DECISION DELEGATED TO DEVELOPMENT MANAGER

Application No: H13-0130-20 **Applicant:** Mr M Ogunade
Proposal: Front porch extension, garage conversion and creation of rear dormer
Location: 7 Benton Close Moulton Chapel Spalding
Terminal Date: 20th October 2020

Proposed Plans and Elevations
 Shed Roof

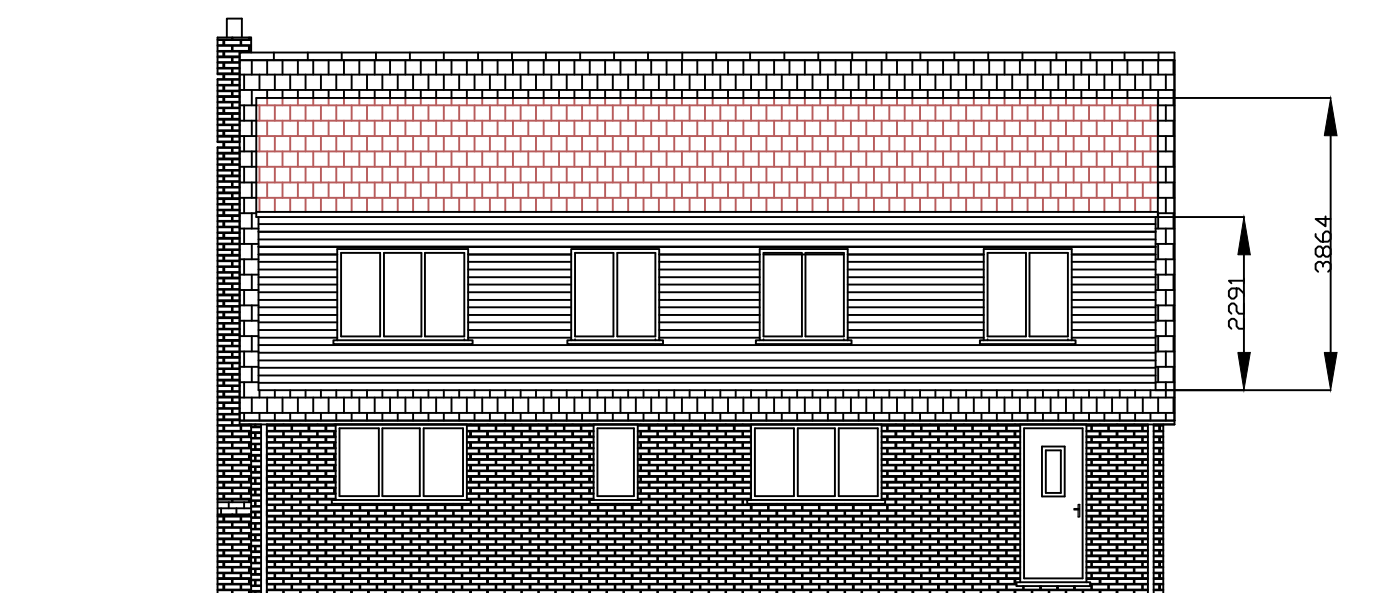
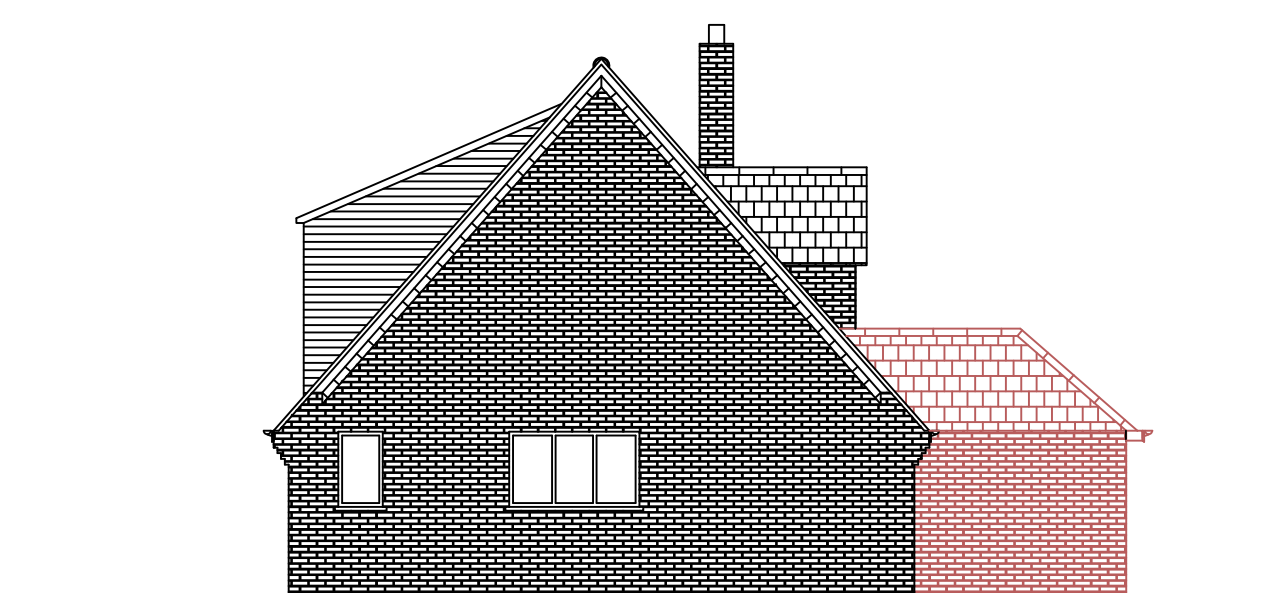
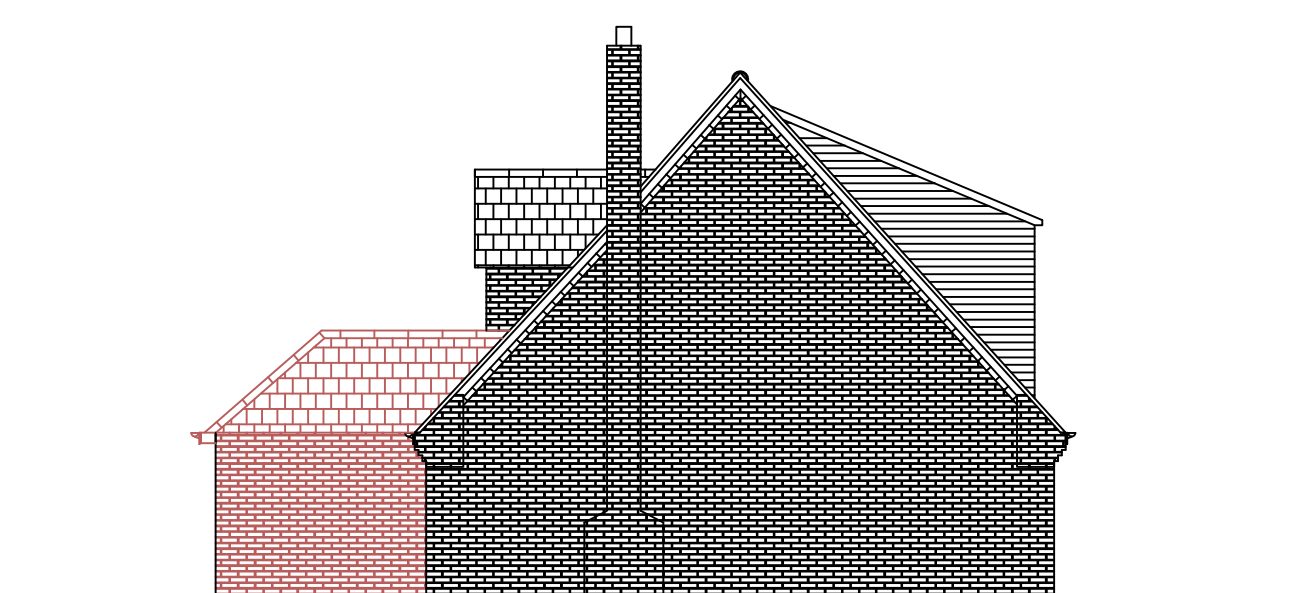
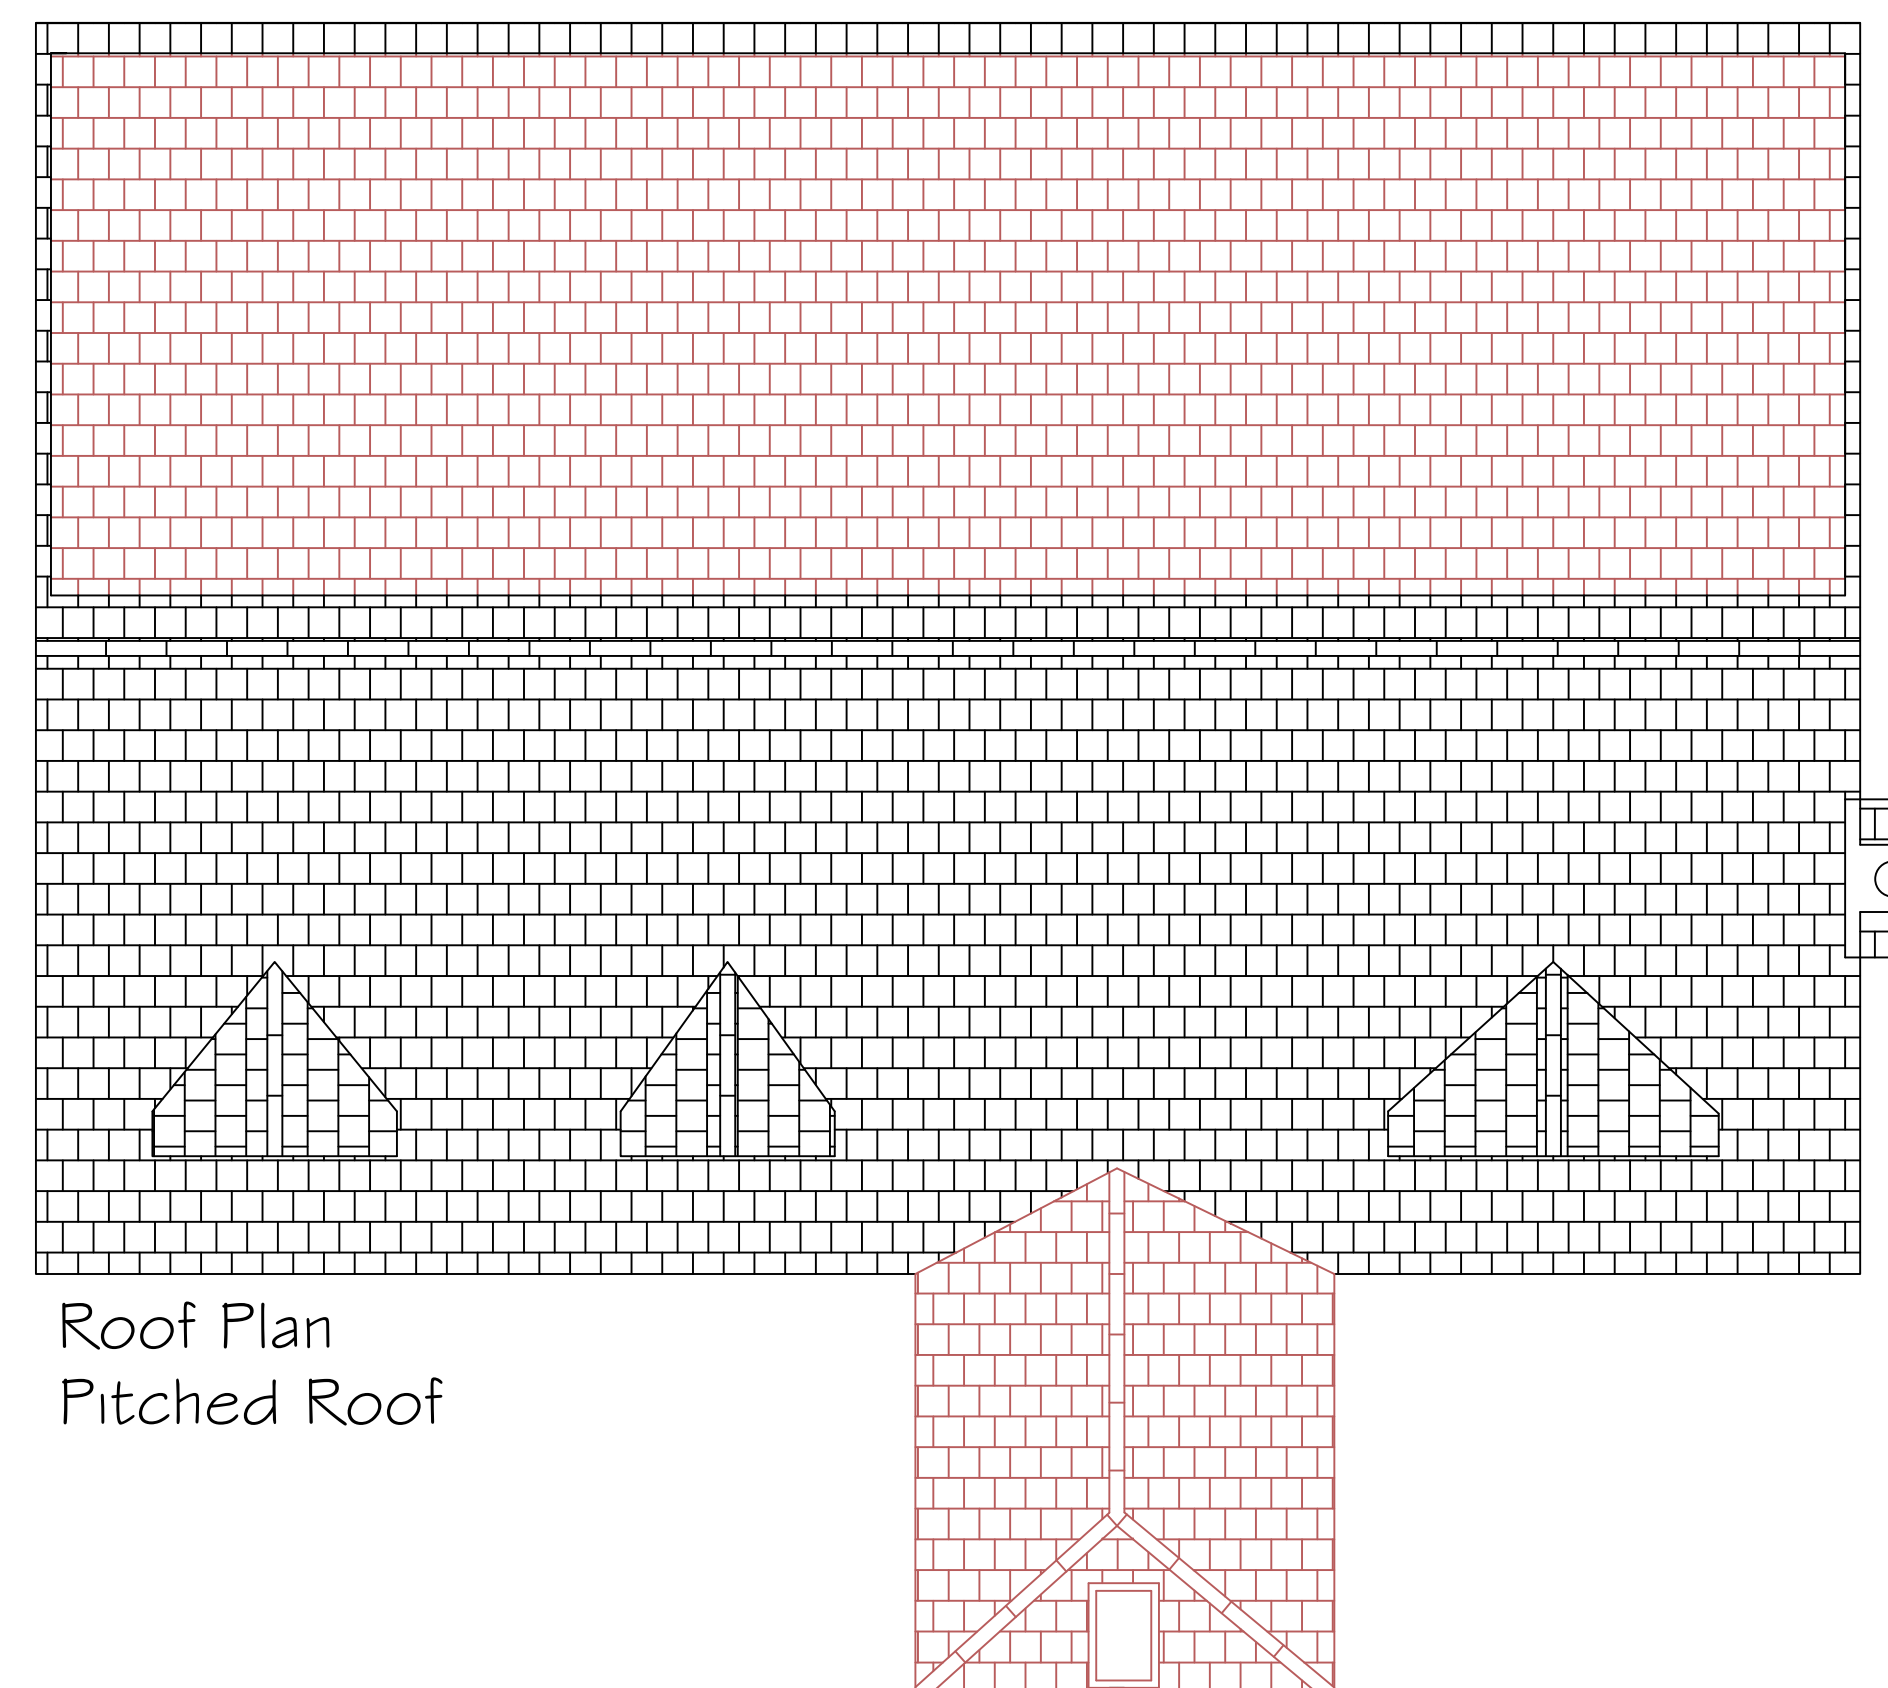
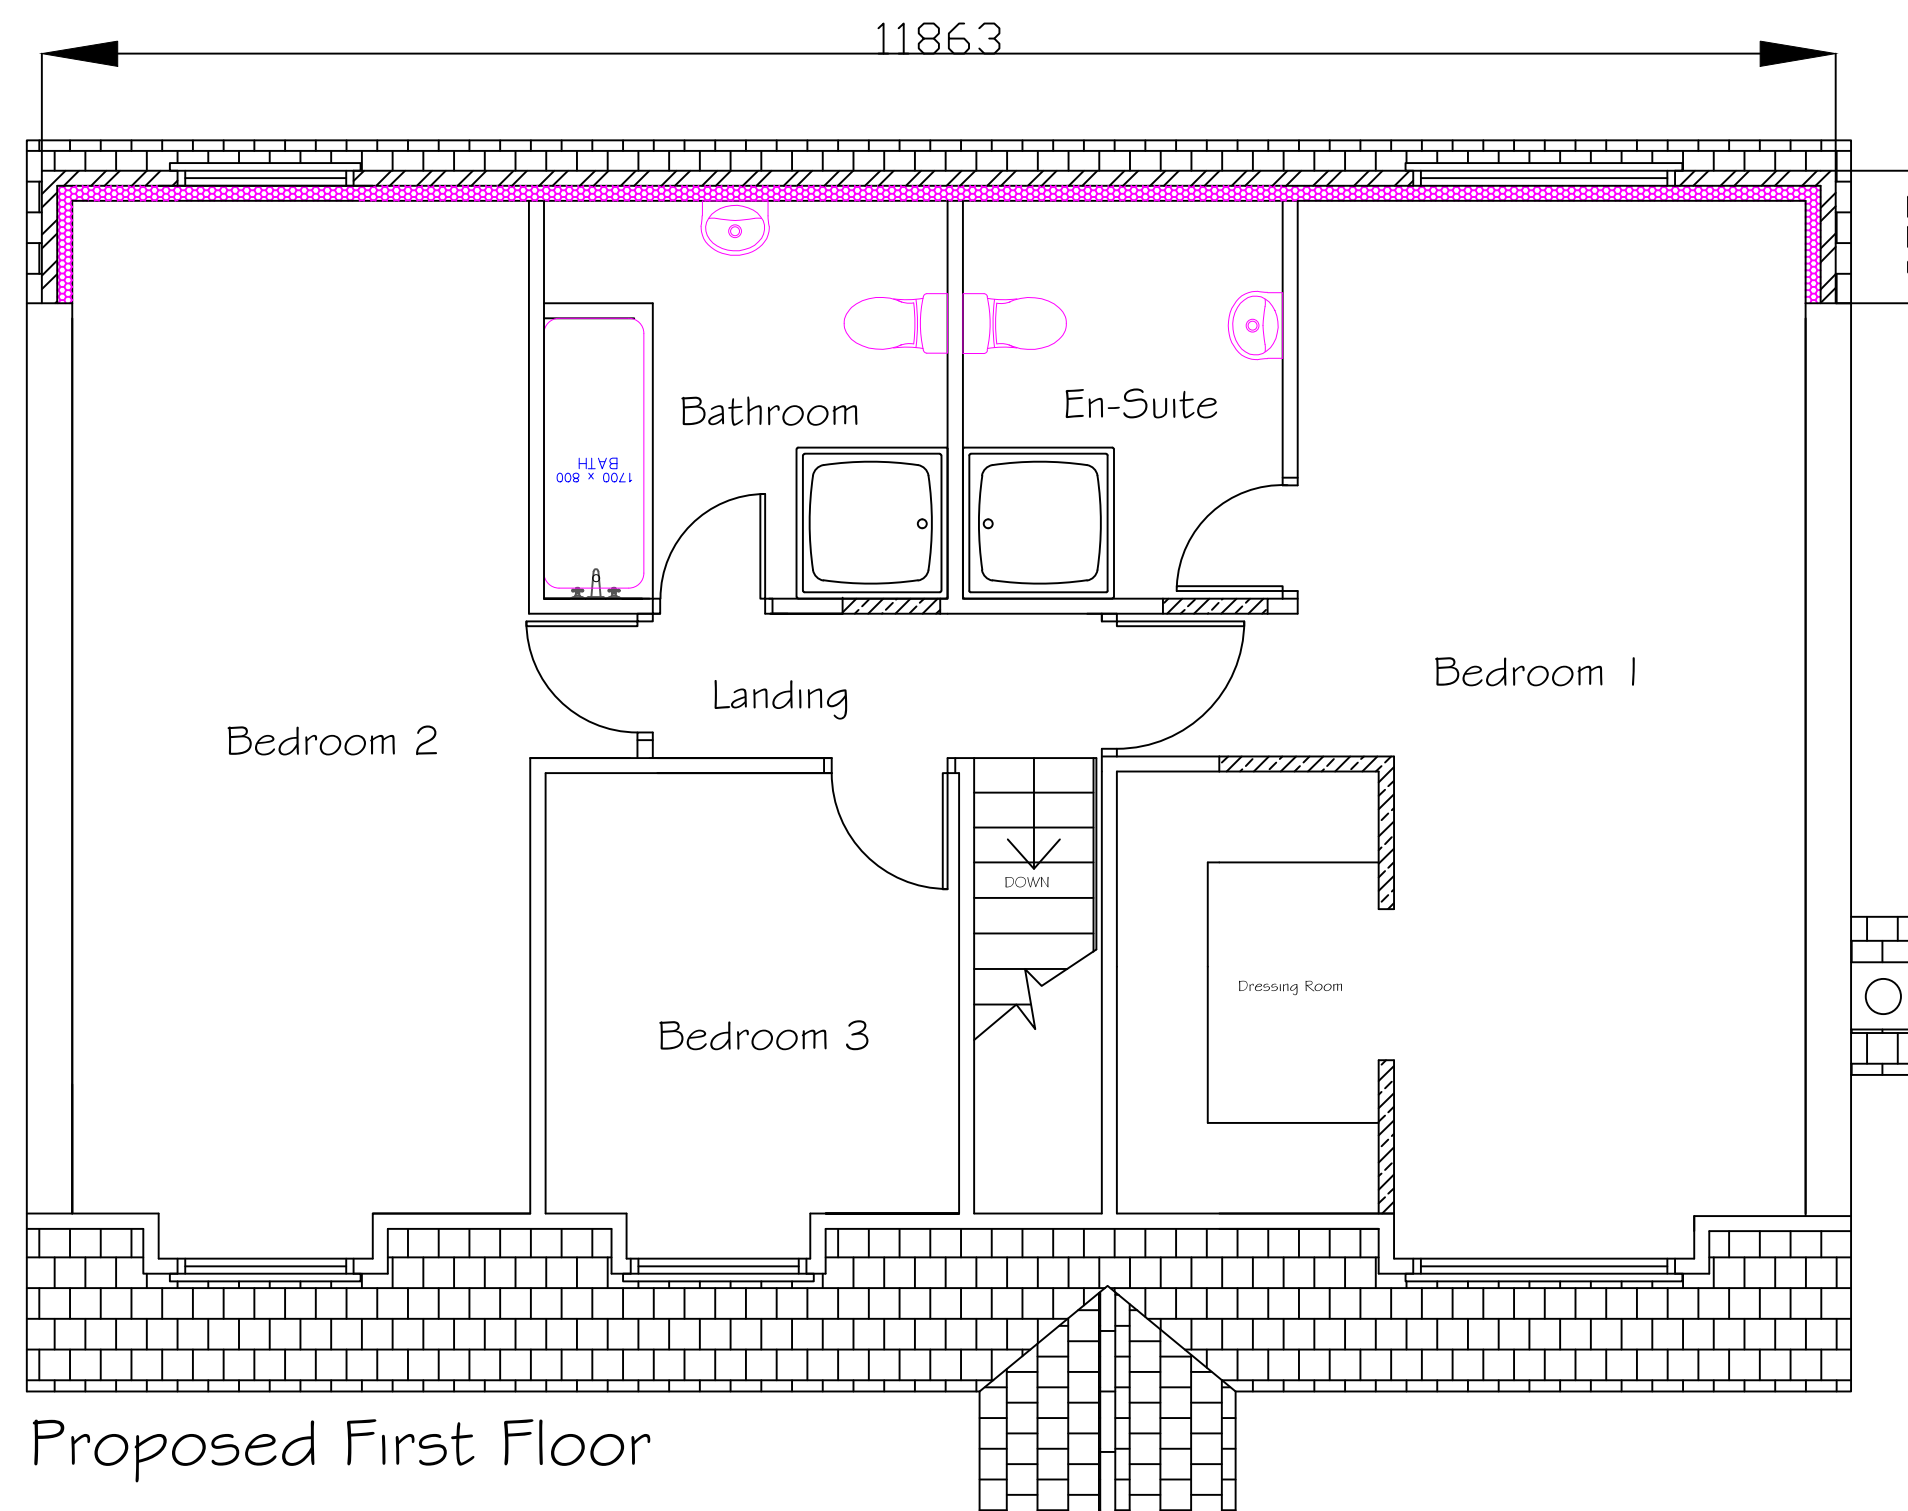
The rear dormer will be set back approximately 65 centimetres from the outer edge of the eaves, and 80 centimetres from the gable pitch of the dwelling. It will extend nearly the full width of the roof slope. The form of development is such that the rear dormer will be subservient to the host property

The front porch will be bricked in all external elevations. A hip roof will be on top of the porch which will provide further variety to the mixture of gable pitches on front dormer windows and shed roof on the rear dormer. Formerly, the proposals include a box style rear dormer. The revised plans have replaced the flat roof for a shed roof which will avoid an eyesore and contribute to soften the sharpness of the form of development and, ultimately, deliver a high quality designed loft conversion.

There have been objections received during the consultation process. The main issue is the potential overlooking effect from the windows of the proposed rear dormer to the adjacent rear gardens. It worth mentioning that the property currently has roof lights on the rear roof slope which might already lead to somewhat overlooking effect. In fact the proposed windows will be larger than the existing roof lights even though the field view and angle of vision will be similar. The loft users will have still restricted vision to both sides (gardens of properties at No. 6 and 8) and direct views onto the rear gardens of properties at Roman Road.

However, the direct views would not create a significant loss of privacy neither in the exterior amenity areas nor habitable spaces. The garden of the application property is approximately 10 metres long and the lengths of rear gardens of properties No. 30, 32 and 34 Roman Bank are in the region of 30 metres. Furthermore, the nearest and approximate distances between the rear dormer windows and the rear elevations of No. 30, 32 and 34 Roman Bank are 43, 34 and 33 metres respectively.

The shed roof for the rear dormer is well-regarded in comparison with the formerly proposed box dormer. Although some concerns on overlooking effect from the intended dormer, the field view from the new openings and existing separation distances with properties to the south will not entail any exacerbation of overlooking effect respecting the current roof lights on the rear roof slope.

with the agent, revised plans were submitted showing a shed roofed dormer. The number of four windows remains.
